Application No: K/26/21/HH
Site Address: 109 Golden Avenue East Preston BN16 1QT
Description of works: Erection of two storey rear extension with juliet balcony, front porch extension and reroofing of existing front garage

Thank you for your internet representation made on 8th June 2021 which has been recorded as an objection with the comments as follows:

A 03

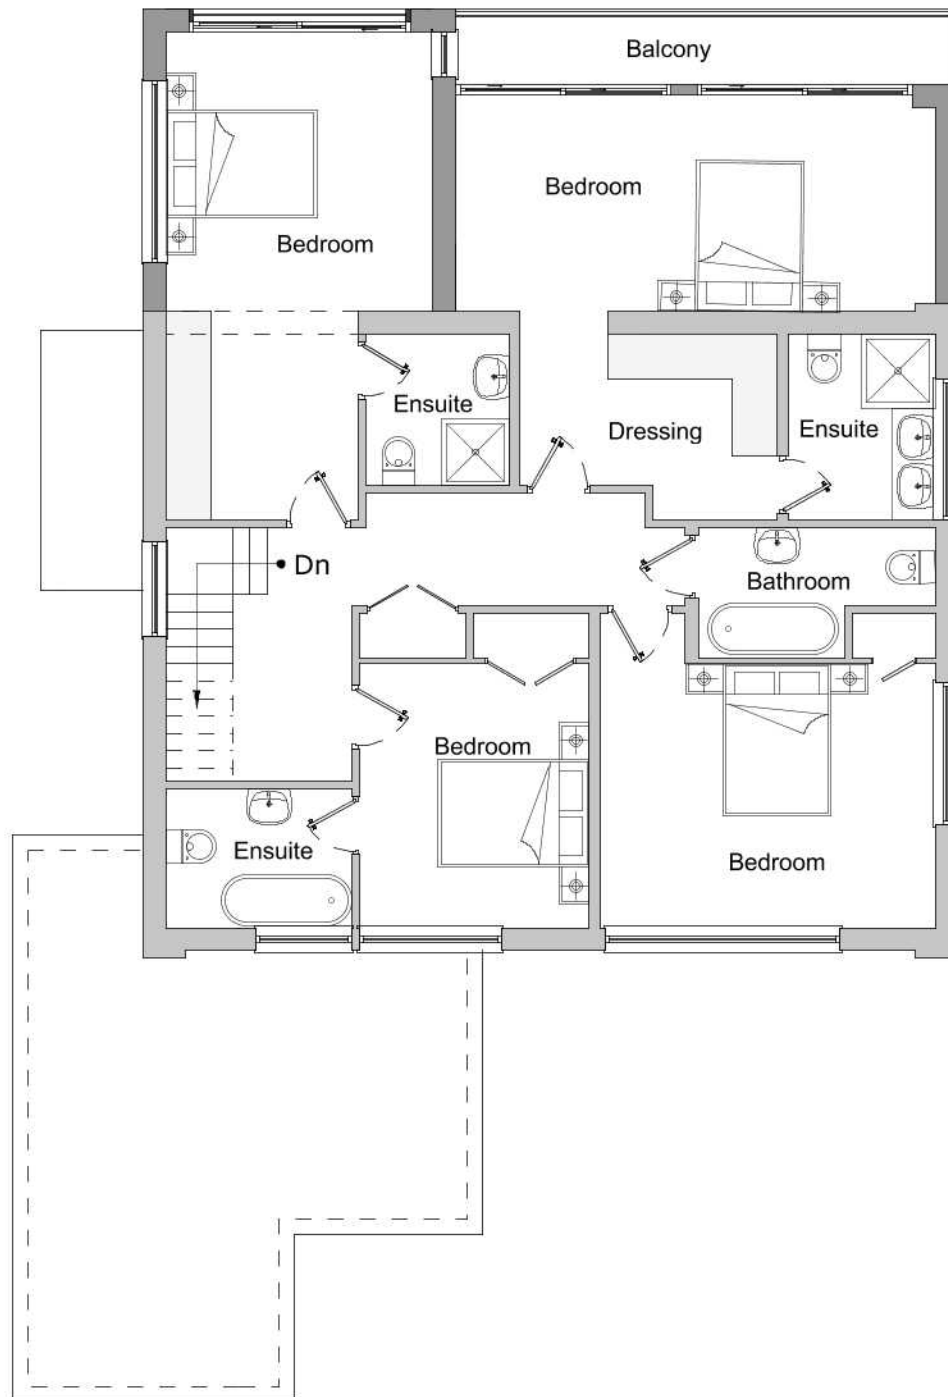
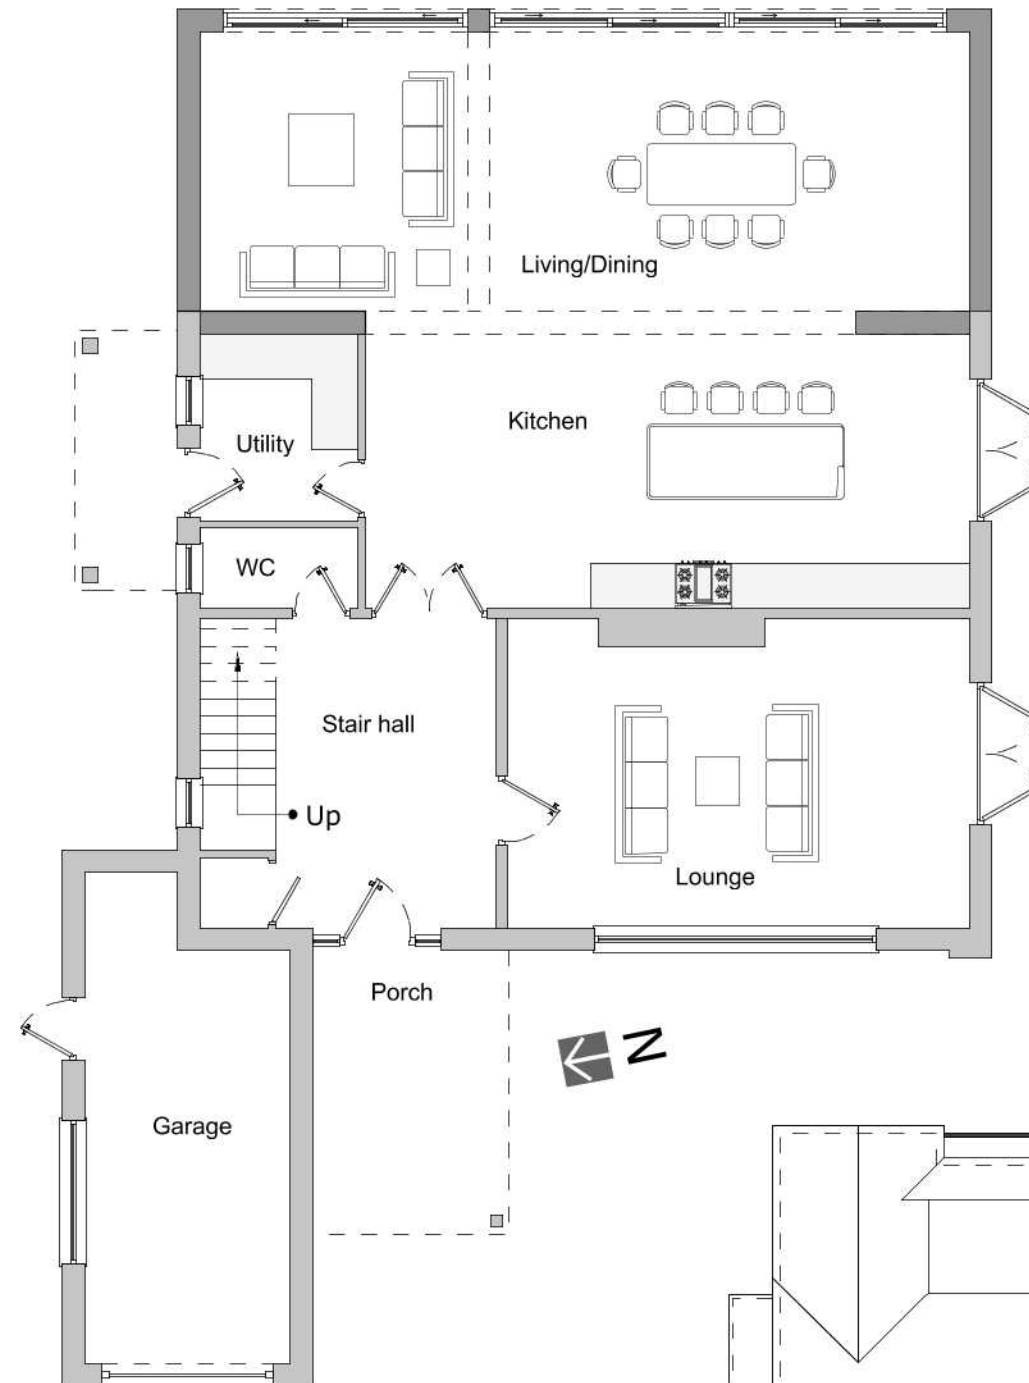
In principal I am happy with this application my only objection is to the walk out balcony which will set a precedence for others to follow suit and compromise the privacy of neighbouring properties. I would have no objection to a Juliette balcony.
